Re: Major Projects – New Request for Advice - Moorebank Intermodal Precinct West - Stage 3 (SSD-10431)

This letter is in response to the Moorebank Intermodal Precinct West - Stage 3 (SSD-10431) Response to Submissions provided by the proponent Sydney Intermodal Terminal Alliance (SIMTA). Council previously provided a formal letter of submission (dated 1 June 2020) regarding the proposal.

PLAN OF SUBDIVISION OF LOT 1 IN DP1197707 AND
 LOT 100 DP1049508

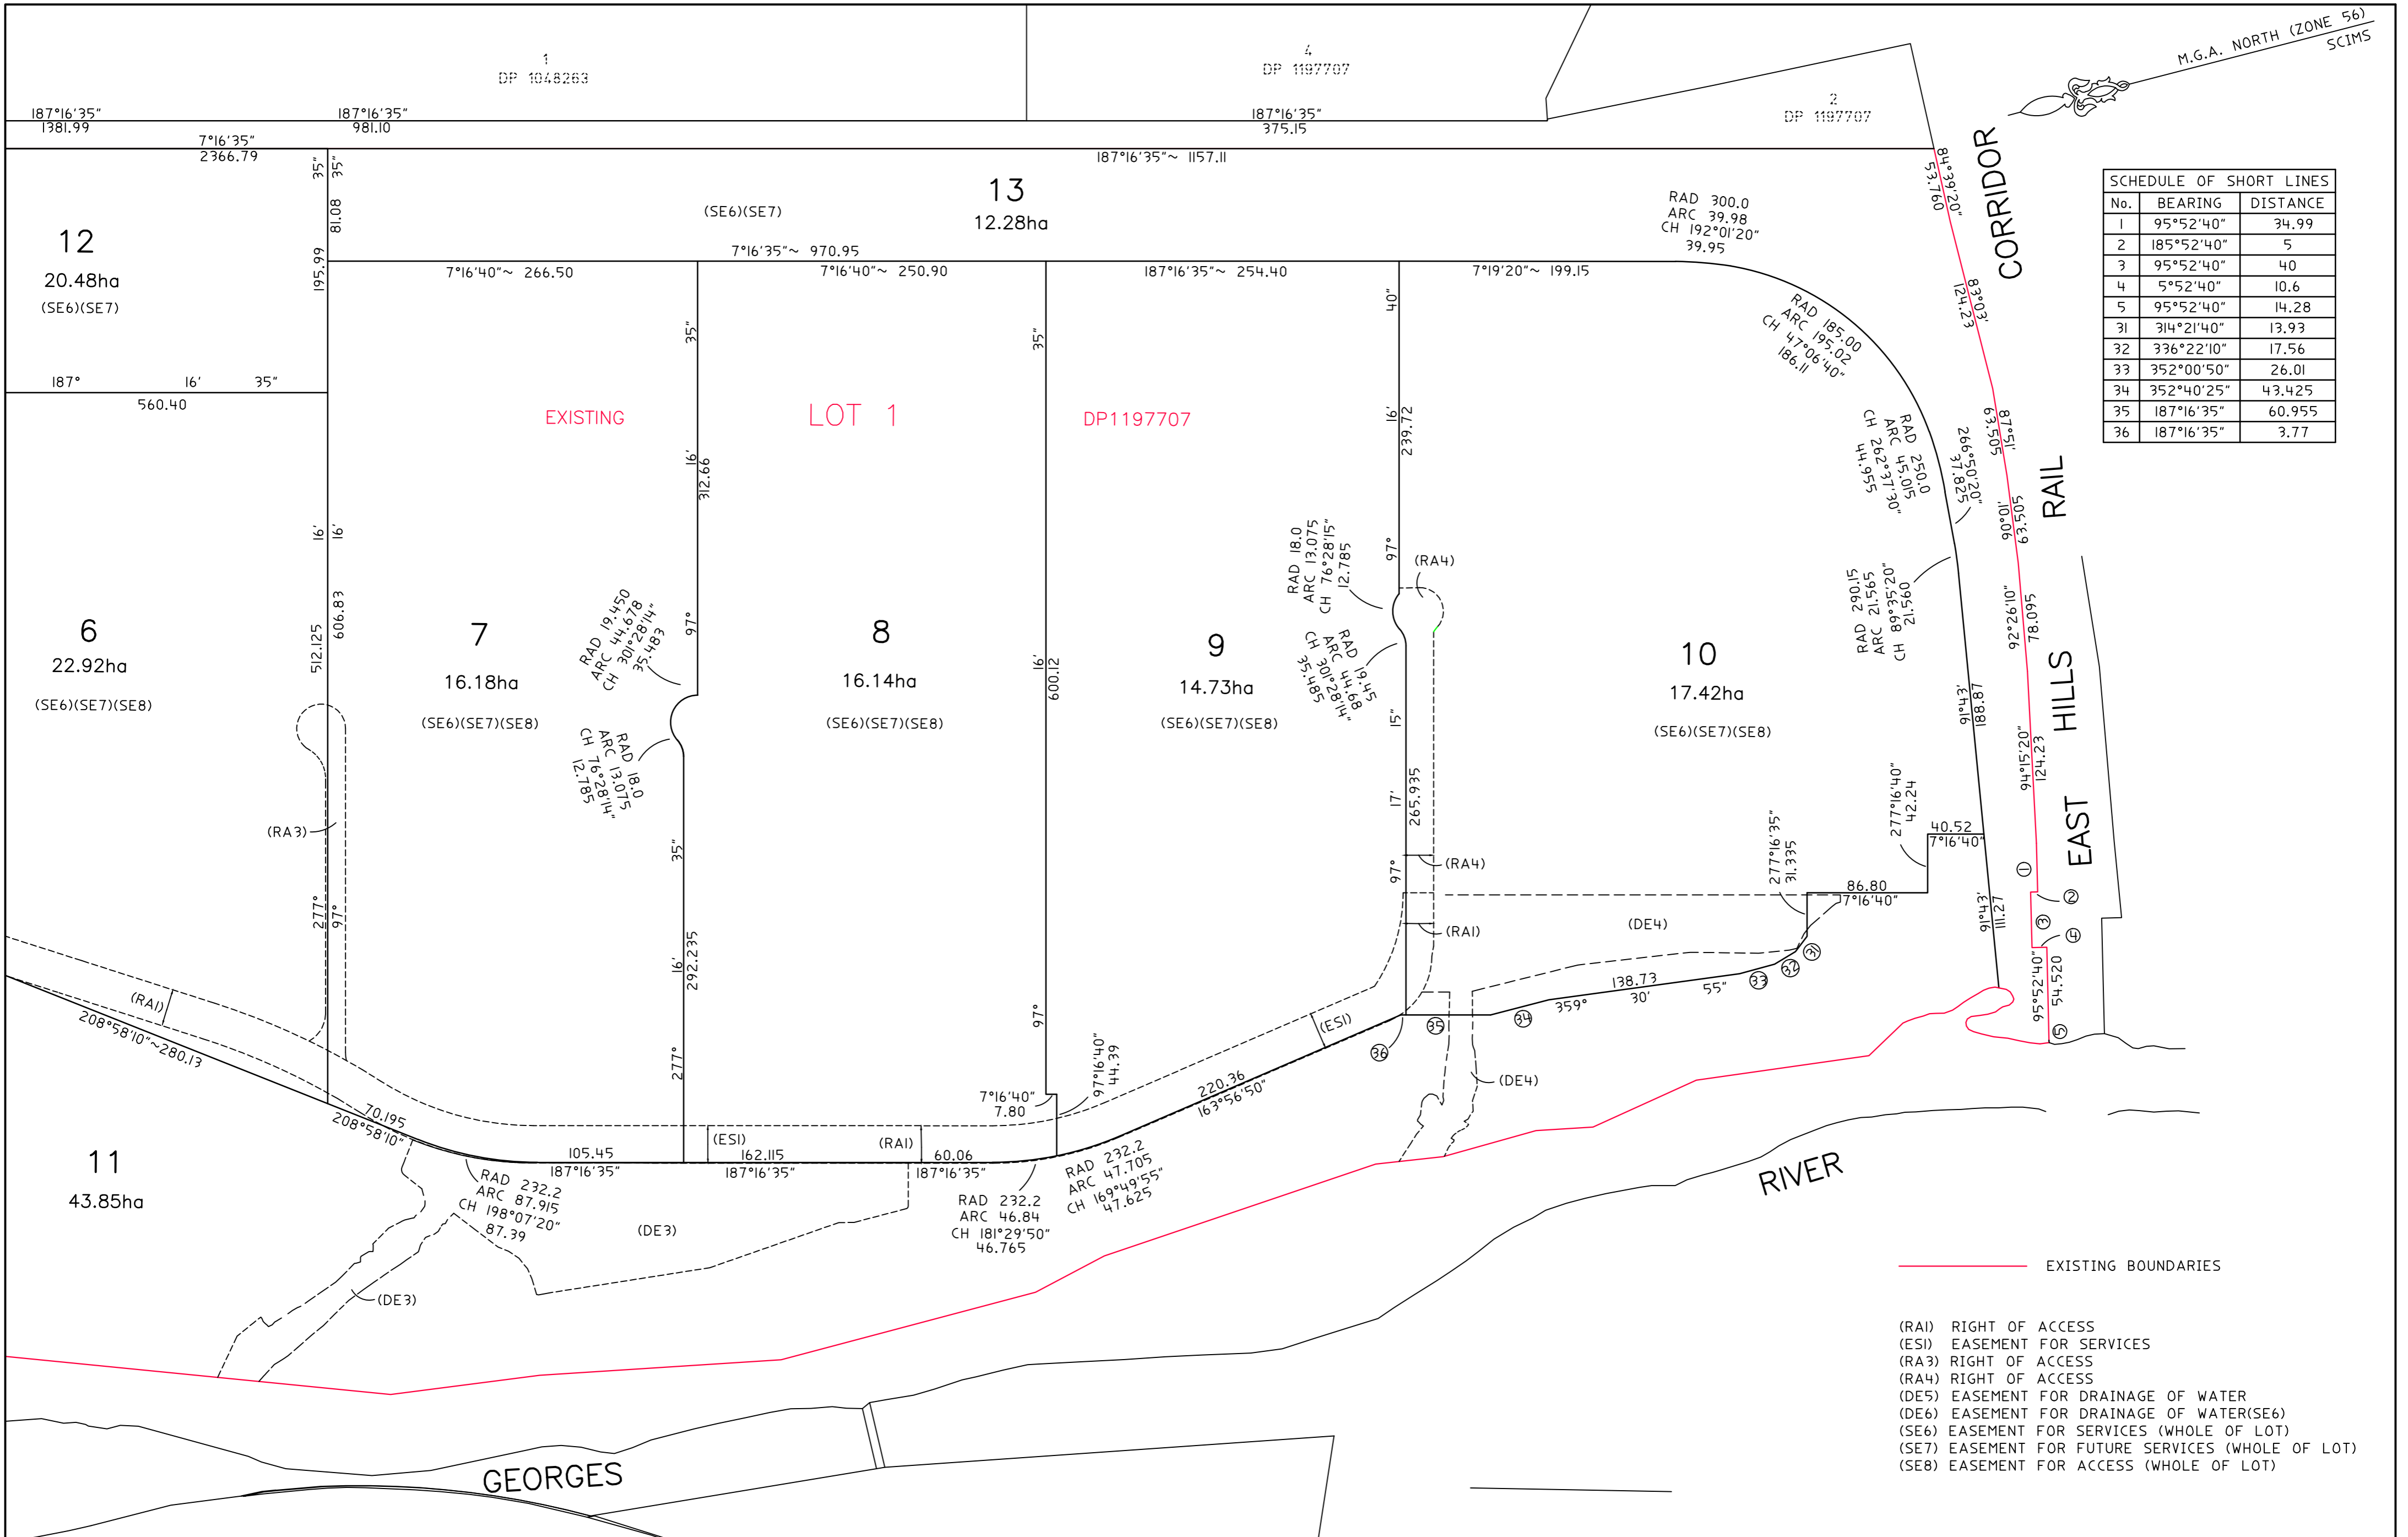
Council maintains its objection to the proposal, particularly the proposed subdivision and resulting non-compliance with Clause 4.1 of the Liverpool Local Environmental Plan 2008. It is acknowledged that Aspect Environmental Pty Limited has provided the Response to Submissions document that specifically responds to Council's concerns regarding the proposal in Section 4.12 of the document.

It is noted that the development consent as modified includes conditions to enable the subdivision of the site as part of a future development application. It is also acknowledged that the proposed subdivision is seeking the separation of functions for the MPW site. However, the subdivision proposed currently seeks further separation than to simply separate MPW functions, with distinct warehouses and groups of warehouses separated into individual lots. It is reinforced that Council wishes to safeguard the holistic operation and management of the MPW site and avoid the creation of an industrial park or estate development.
